From: rogersbigtone@aol.com [REDACTED]
Sent: 04 October 2018 14:57
To: Anita Gardner
Subject: Re: R/152/18/DOC - Landscaping condition - 2 Broadmark Lane, Rustington

I have today received the comments of the Landscape Officer. She has stated 'The information submitted in dwg 15/1091/02 rev C has not been supplied in sufficient detail. The landscape planting detail needs to be included in plan form with species choice and actual proposed plant numbers, densities and height at time of planting. The drawings submitted at present are lacking this detail.'

Layout Plan 1:200

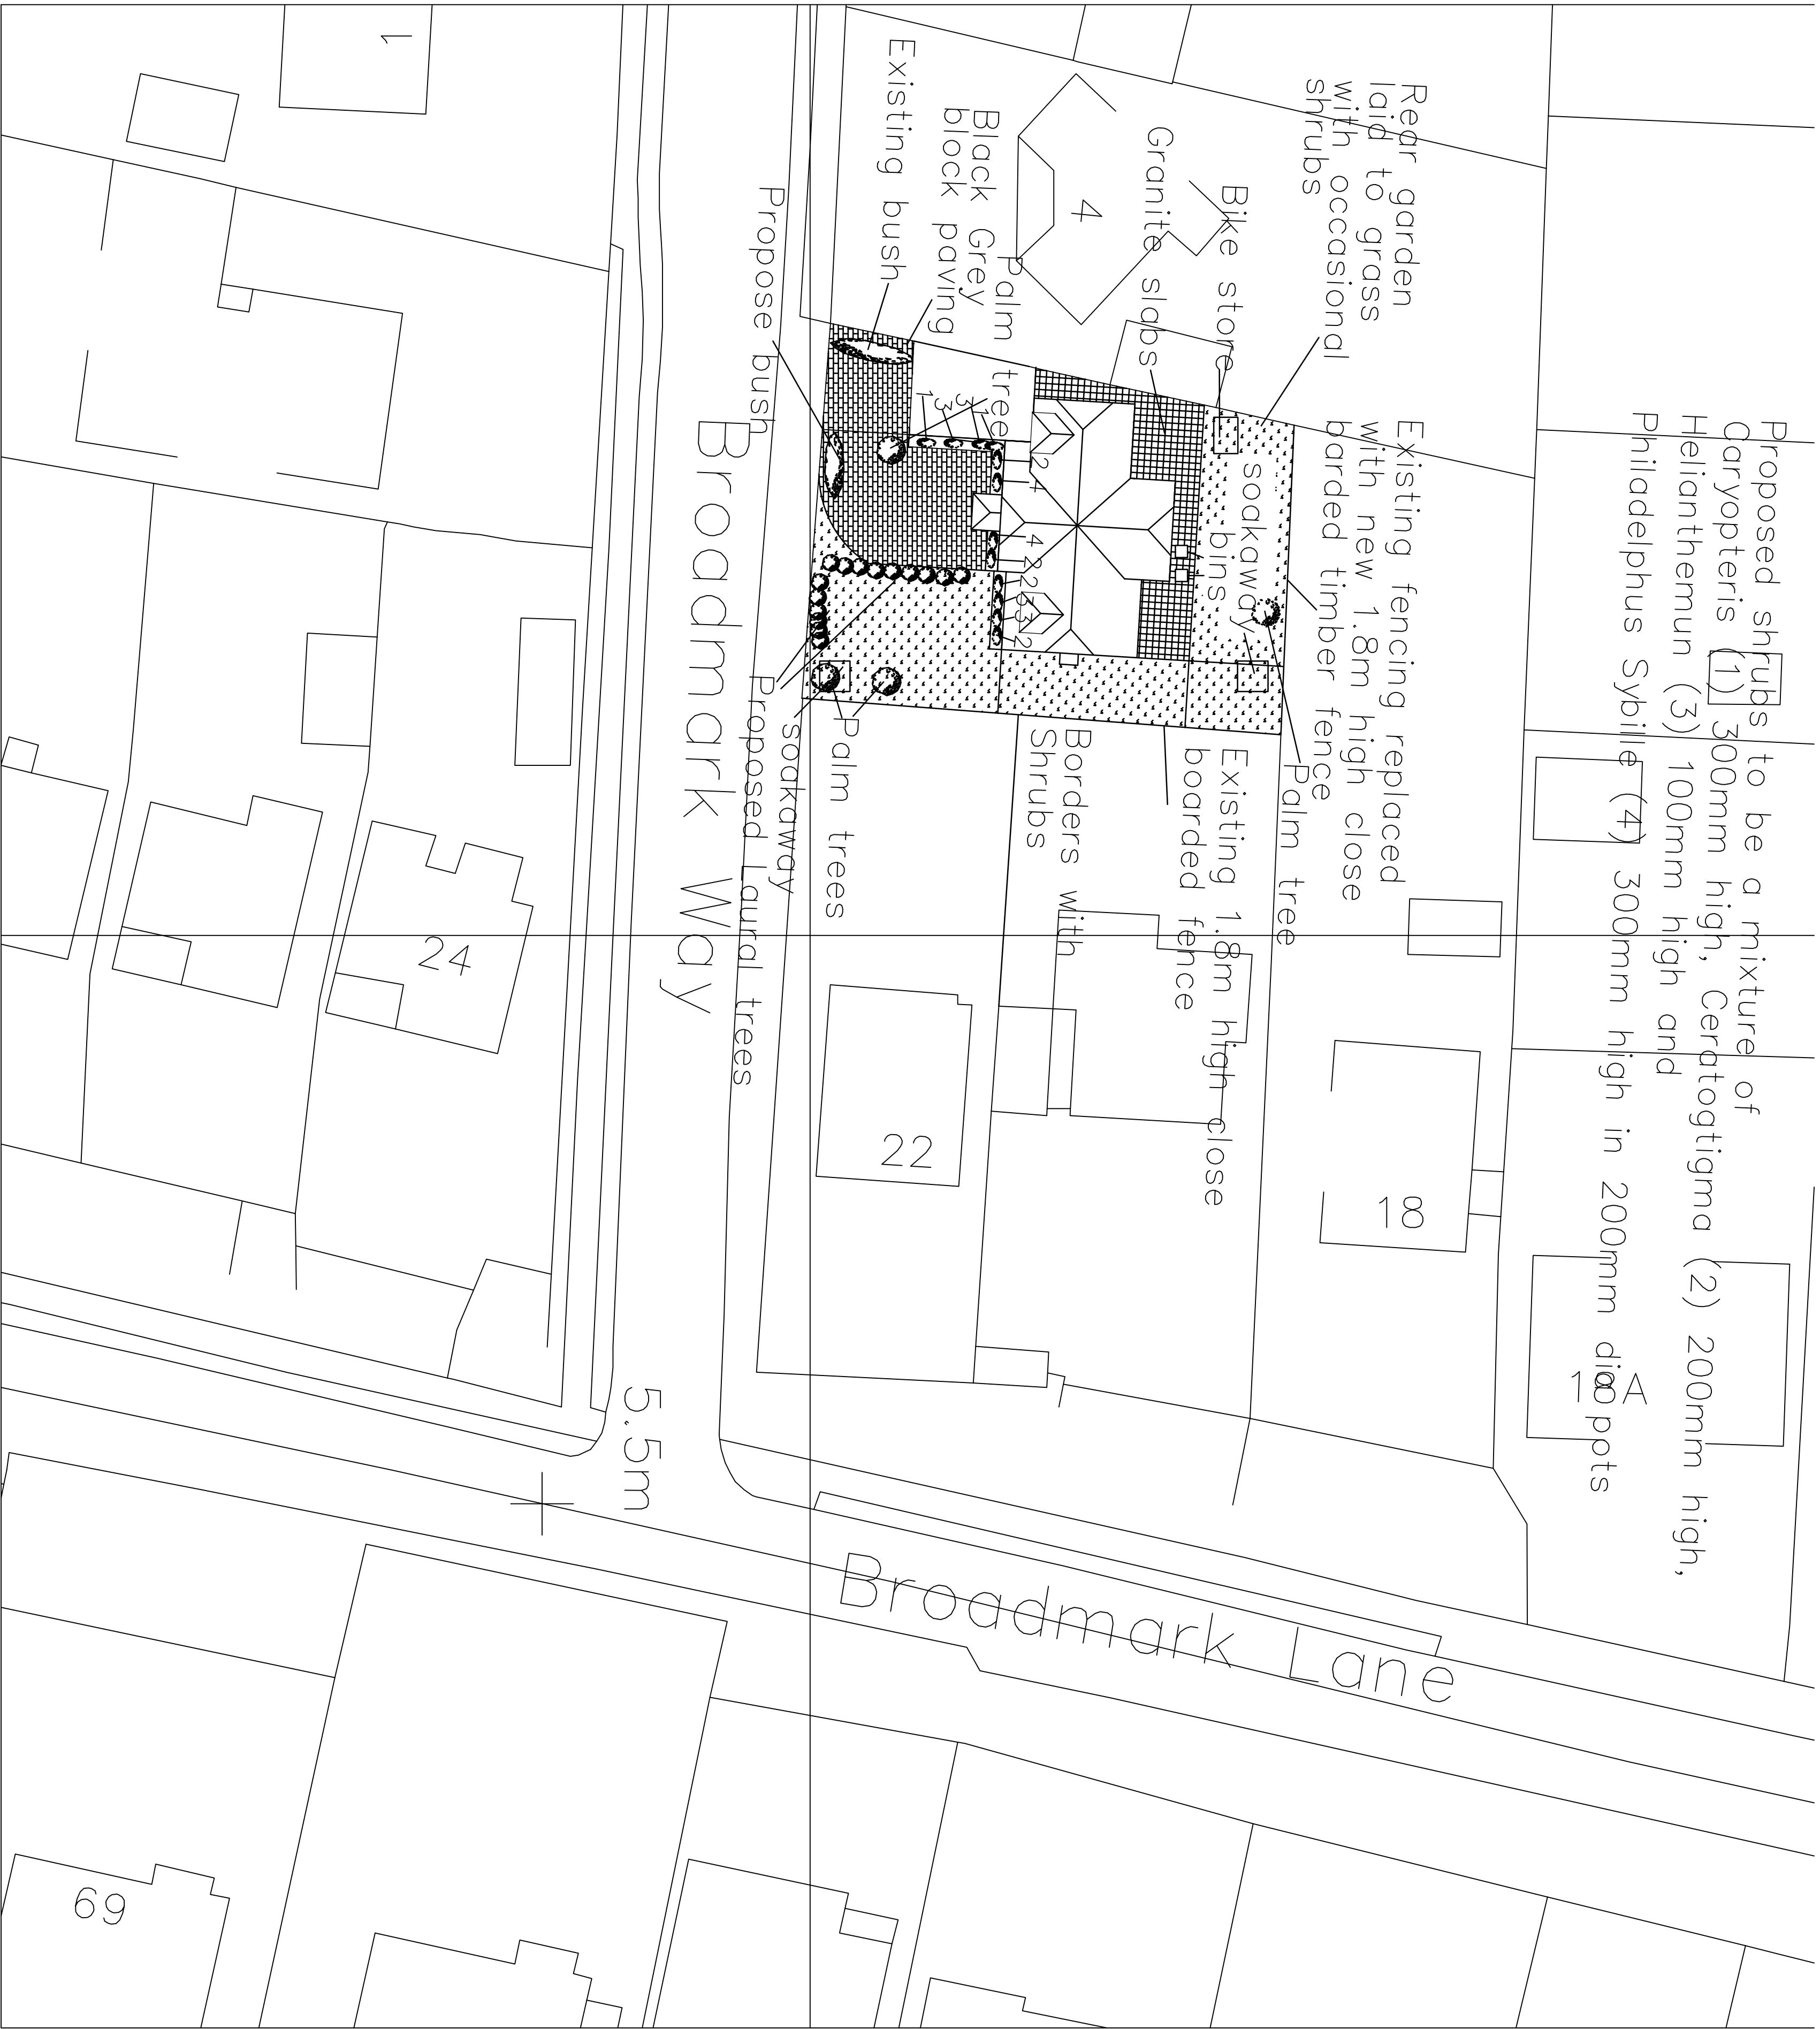
Dear Tony,
There are 2 bushes indicated in the front garden area. . One is existing , one is proposed are you saying that they are both existing? I also still require confirmation of the number of Laurels proposed.
Regards
Anita

Dear Tony,
Thank you. Can you also confirm the species and size of the proposed bush indicated in the front garden?
Anita

Dear Tony,
What about the size of the palm trees, the number and size of laurels on the site frontage and the bush on the site frontage? Can these details be confirmed please? They don't need to be indicated on plan, but I would appreciate conformation by e-mail which can then be added to the application.
Regards
Anita

One is existing the other is proposed. The number of laurels is 15.

It will be as existing.

The palm trees will be 900mm high, the laurels 900mm high as for the hedging.
